Application for a non-material amendment following a grant of planning permission.

Number	86
Suffix	
Property name	
Address line 1	Sea Road
Address line 2	
Address line 3	
Town/city	East Preston
Postcode	BN16 1NP
Description of site location must be completed if postcode is not known:	
Easting (x)	507103
Northing (y)	101867
Description

SINGLE STOREY REAR EXTENSION AND TWO STOREY FRONT EXTENSION

Reference number: EP/148/18/HH

PROPOSED EAST ELEVATION 1:100

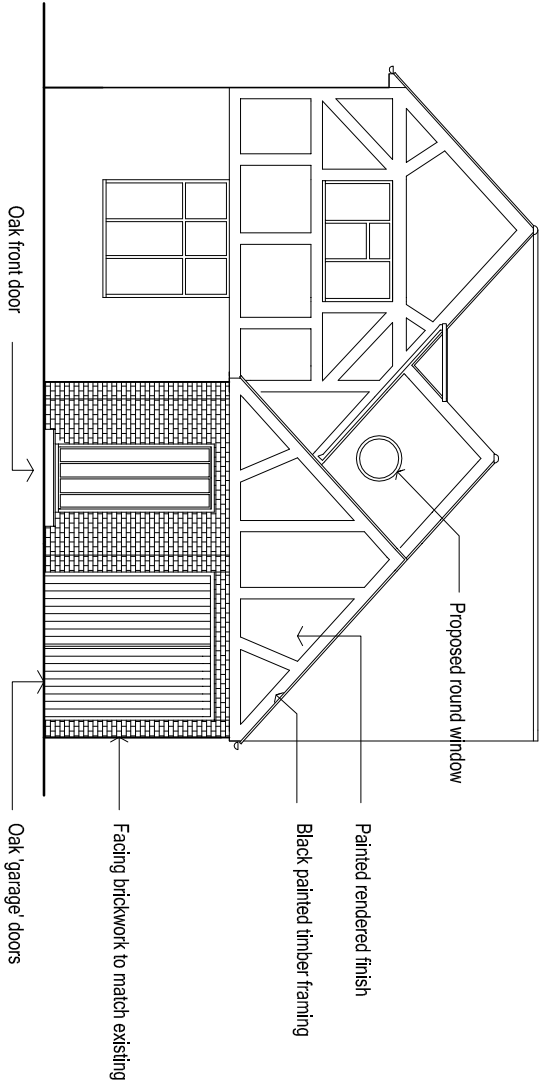
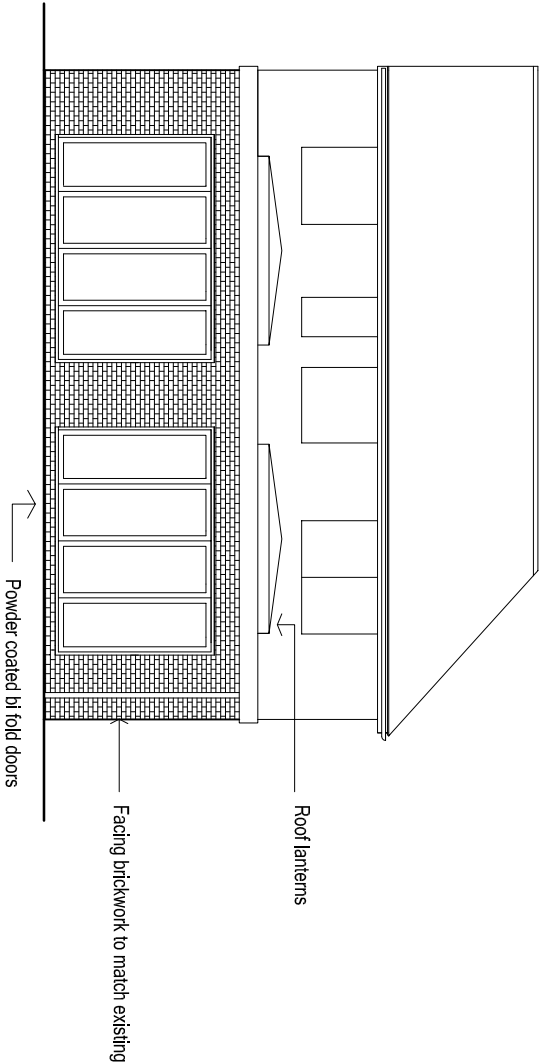
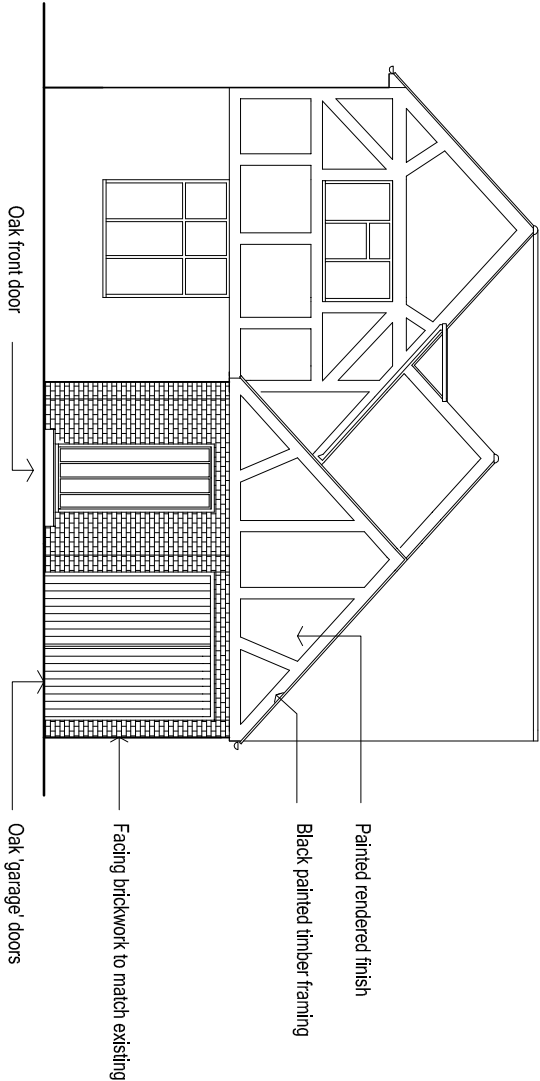
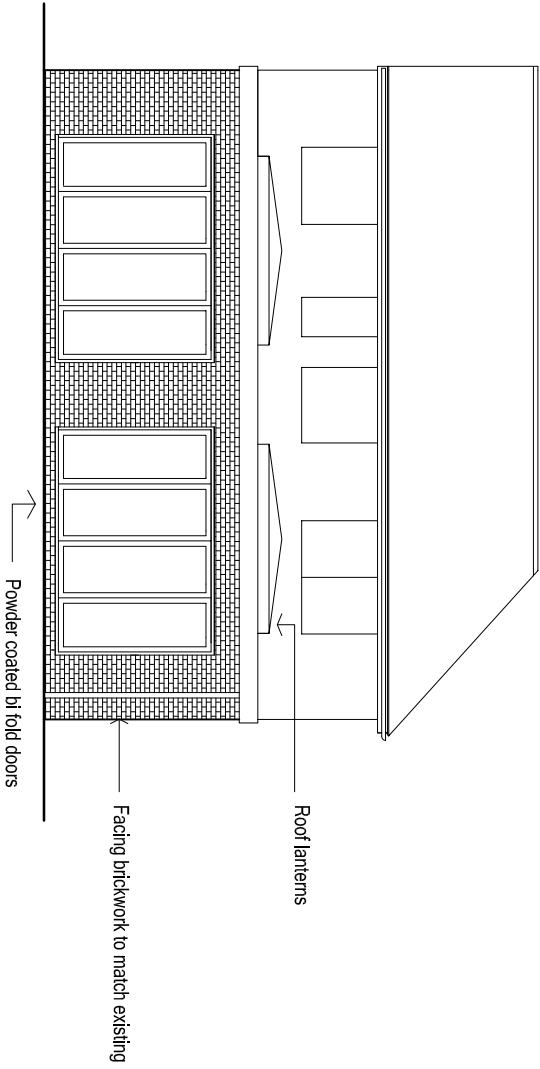
ADDITION OF A ROUND, 600mm DIAMETER, WHITE PVCU WINDOW TO FIRST FLOOR EN SUITE BATHROOM ON EAST ELEVATION

TO ALLOW MORE LIGHT INTO BATHROOM
